ITEM 1.8 (b)

85 Harrington Street
The Rocks
GOLDEN AGE & HANNAS THE ROCKS

TITLE
**RESPONSE TO DoPE
ITEM 1.8 (b)**

4 PLAN Level 2
1:500

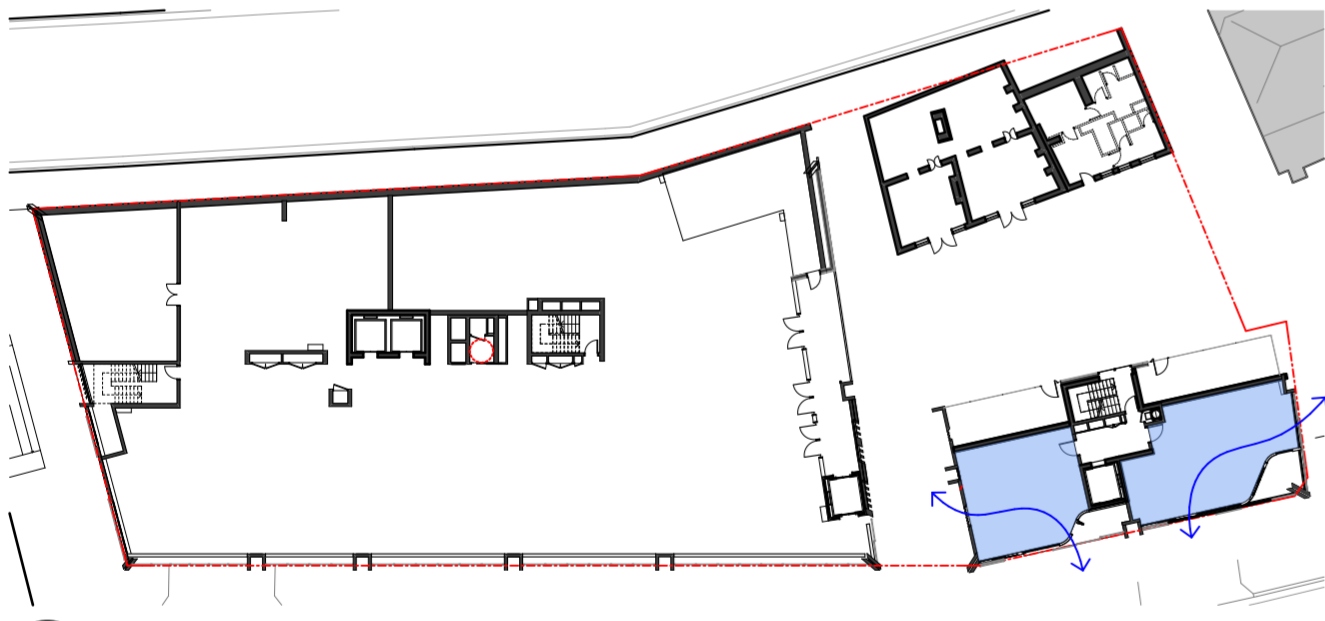
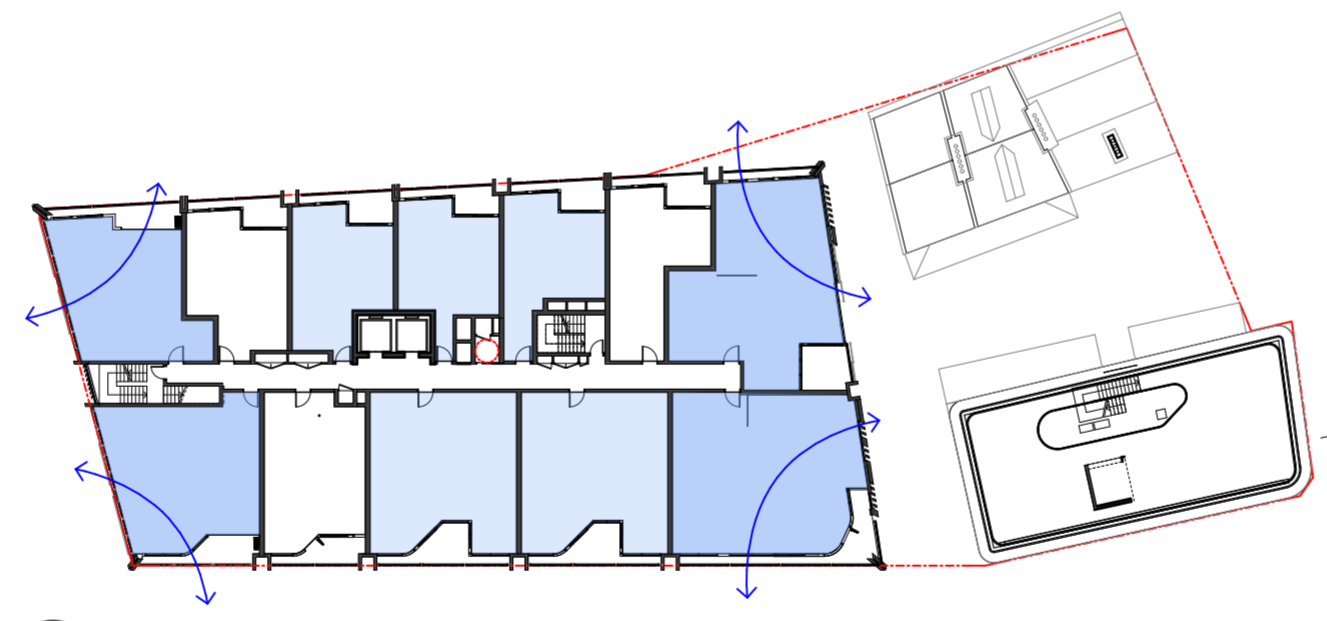
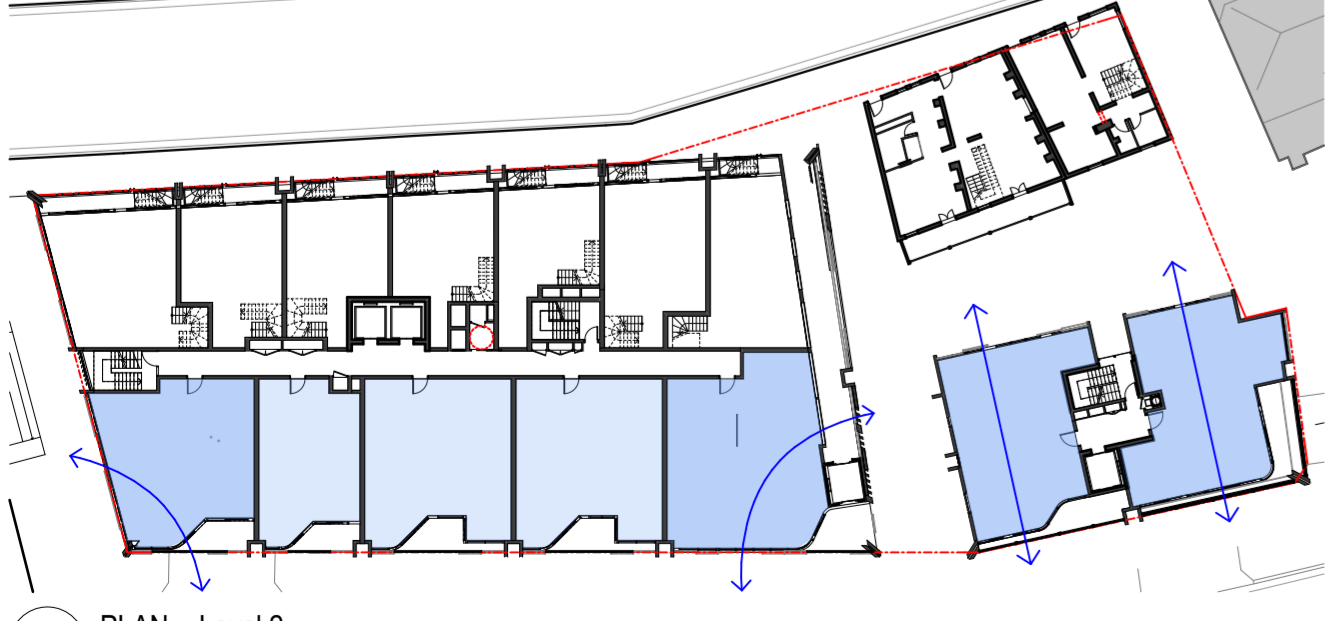
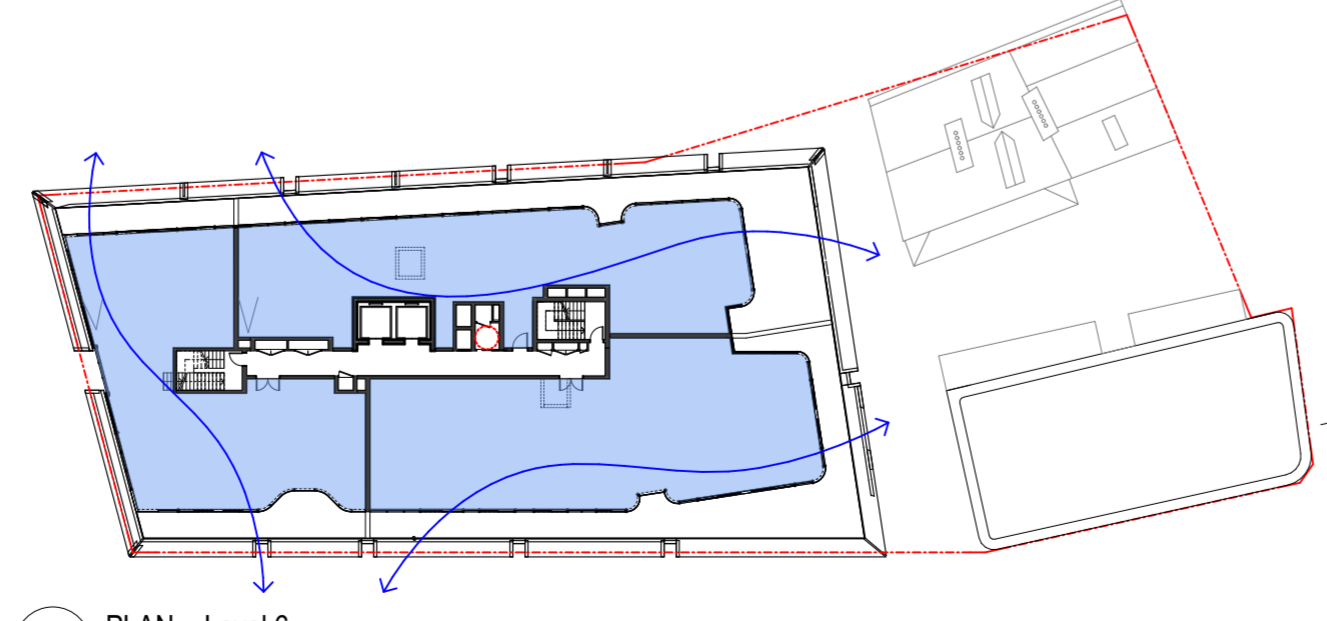
Description:
The Department's overall analysis indicates units 202, 203 and 204 (and identical units on the levels above) may not benefit from a satisfactory level of amenity due to a combination of variations to the Apartment Design Guide design criteria including solar access, cross ventilation, unit depth and/or lack of an external bedroom window.
The Department particularly notes the units which exceed 8 min depth are also not cross ventilated, further reducing effective air flow.
Please undertake further consideration of the design of these units to ensure a suitable level of amenity for future residents is achieved.

Response
Full consideration for the design of the apartments and the development as a whole, has seen a change in response to the points raised by the Department. See the above items 1.3, 1.5(a) and 1.5(b) as evidence of design changes and justification for all point raised.

Solar Access
- Apartments 202, 203 and 204 (and identical units above) are receiving solar access between the hours of 7am - 3pm in mid-winter (June 21st)
